Date 11 March 2024  
Our Ref 24/00257/CLP

**Town and Country Planning Act 1990 (As Amended)**  
**2 Eastcroft Road, West Ewell, Surrey**  
**Lawful Development Certificate - Proposed Use: Single storey rear extension**  
**incorporating rooflights and installation of a rear patio.**

1 SITE PLAN
EX-10 Scale: 1/200

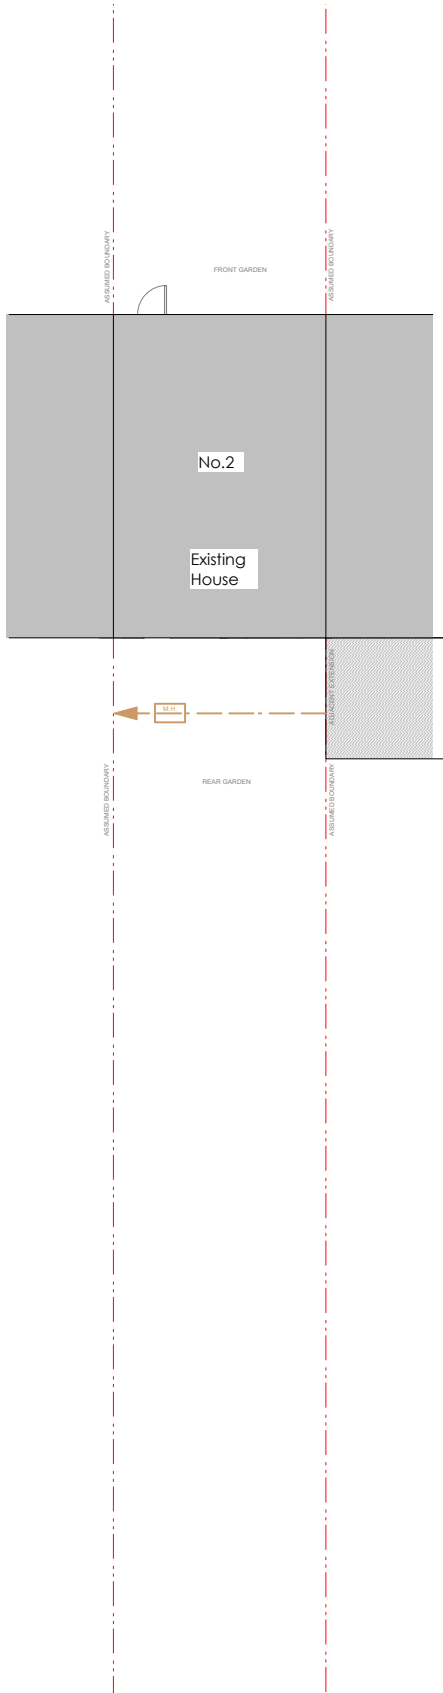
1 EXISTING AND PROPOSED SITE PLAN - Please submit an existing and a proposed Site Plan at a scale of 1:200 or 1:500 showing the proposal clearly differentiating from the existing (e.g. hatched) and its relation to the site boundaries, any other existing buildings on site and the neighbouring properties. The existing site plan is to show the current situation and the proposed plan is to show the proposed situation.
